**KIRKLEES METROPOLITAN COUNCIL
INVESTMENT & REGENERATION SERVICE**

Reference No: 2019/62/93449/W

Site Address: 12, Chapel Street, Scapegoat Hill, Huddersfield, HD7 4NX

Description: Erection of first floor front extension

Drawing No.
PP2019 - DD02

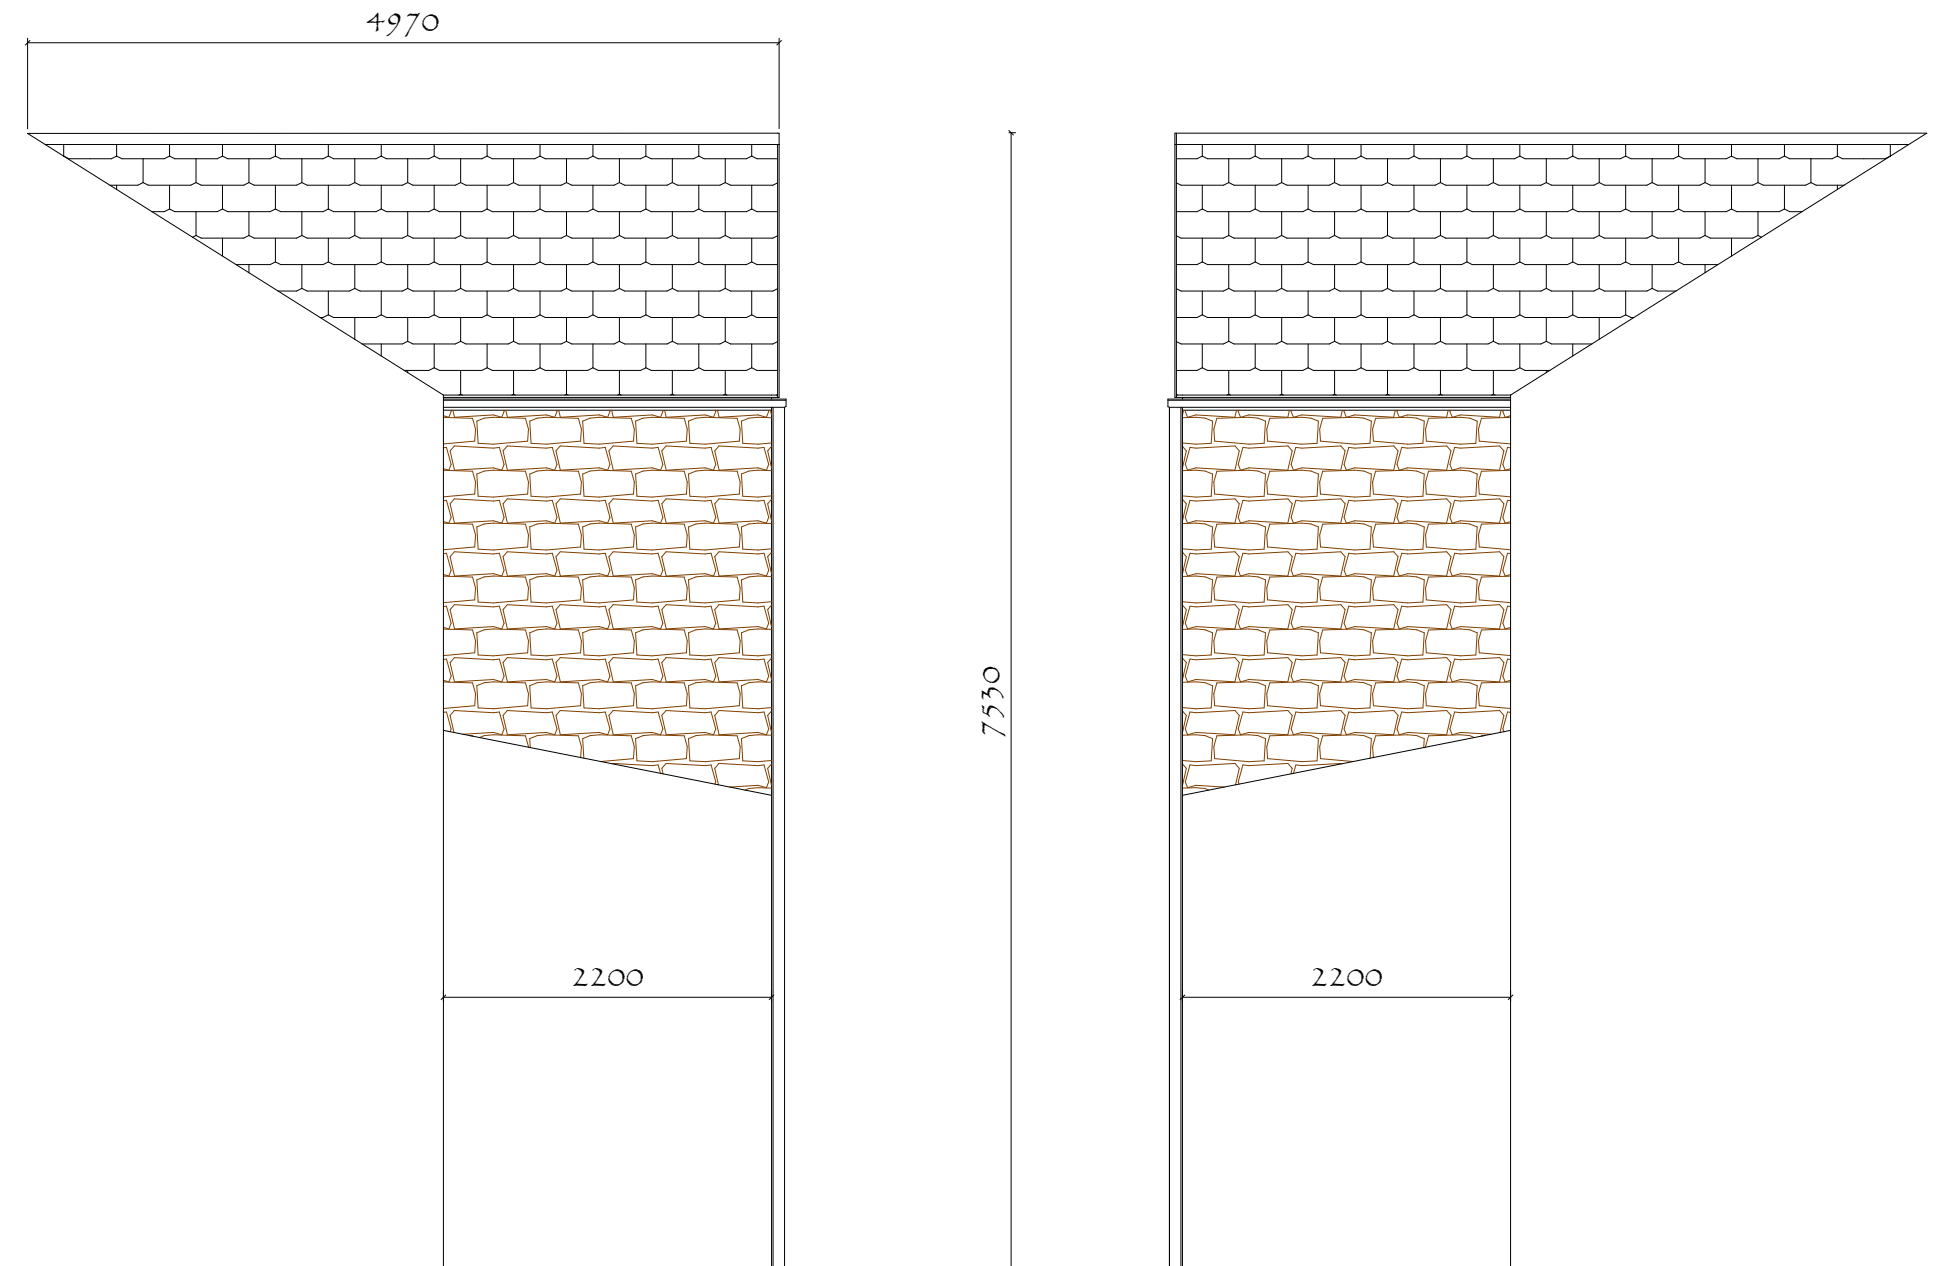
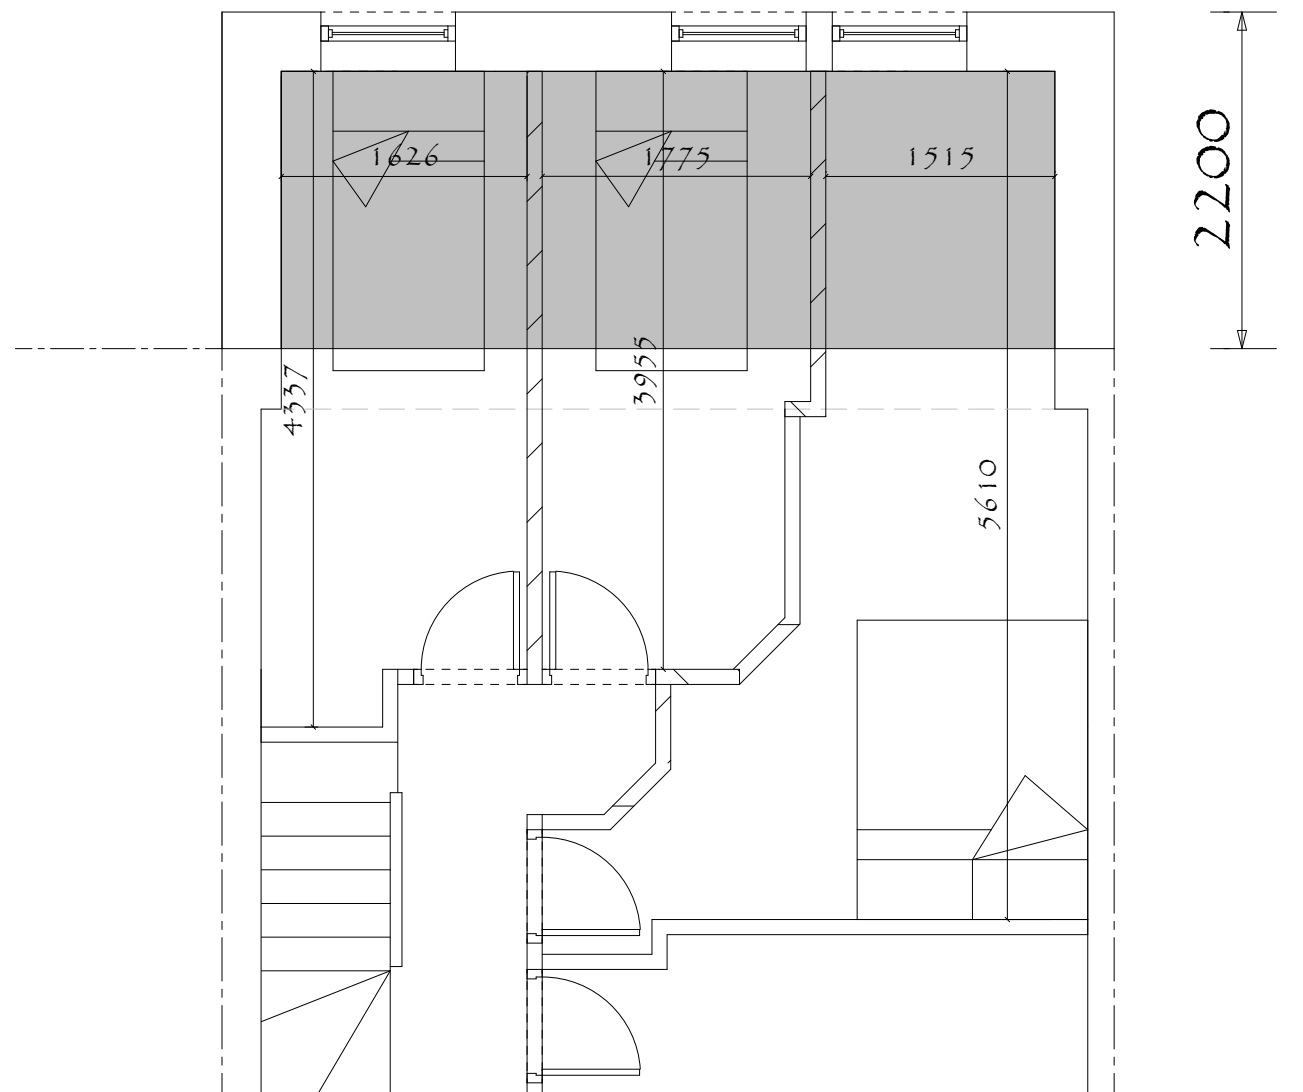
In this instance, it has been considered that the proposed first floor extension would result in an incongruous feature within the street scene, as it would be

located on a prominent front elevation, within a row of largely unaltered properties. It would harm the strong linear form of this terraced row. Furthermore, by reasons of its size and scale, the extension proposed would not be subservient to the host property given the fact that it would adjoin the ridge roof line. The extension will also result in the visual loss of a principal elevation and therefore to permit this would be contrary to Policy LP24 of the Kirklees Local Plan.

Alongside the above, it has been noted that the host property currently benefits from a single storey front extension. Whilst this, is considered to have some impact upon the setting of the row of terraces, the extension appears to be a subservient addition, allowing the host property to be comfortably read within its curtilage. Therefore to permit a first floor extension would result in the loss of the entire front façade at the application site.

14 Chapel Street is the adjoining back to back residential property to no.9 with an existing outlook to the South. As such, it has been considered that there would be some impact on these neighbours amenity, in regards to overbearing and overshadowing. These concerns are also reinforced by the fact that these neighbours are located on a slightly lower level than the host property.

would have a maximum projection of 2.2m, allowing these neighbours to retain a clear outlook from their southern facing openings. Alongside this, any impact on overshadowing would only be evident within an afternoon.

The submitted plans also show no additional openings to be inserted into the Eastern facing side elevation of the existing which will mitigate against any undue impact on overlooking. New openings would also be controlled under the GDPO.

1. The proposed first floor front extension, by virtue of its design, scale and siting would introduce an incongruous and overly prominent feature that would dominate the existing dwelling and which would detract from the strong linear form of the terraced row of which it forms part. This would be harmful to the character and appearance of the area and contrary to Policy LP24 (a and c) of the Kirklees Local Plan and the aims of Chapter 12 of the National Planning Policy Framework.
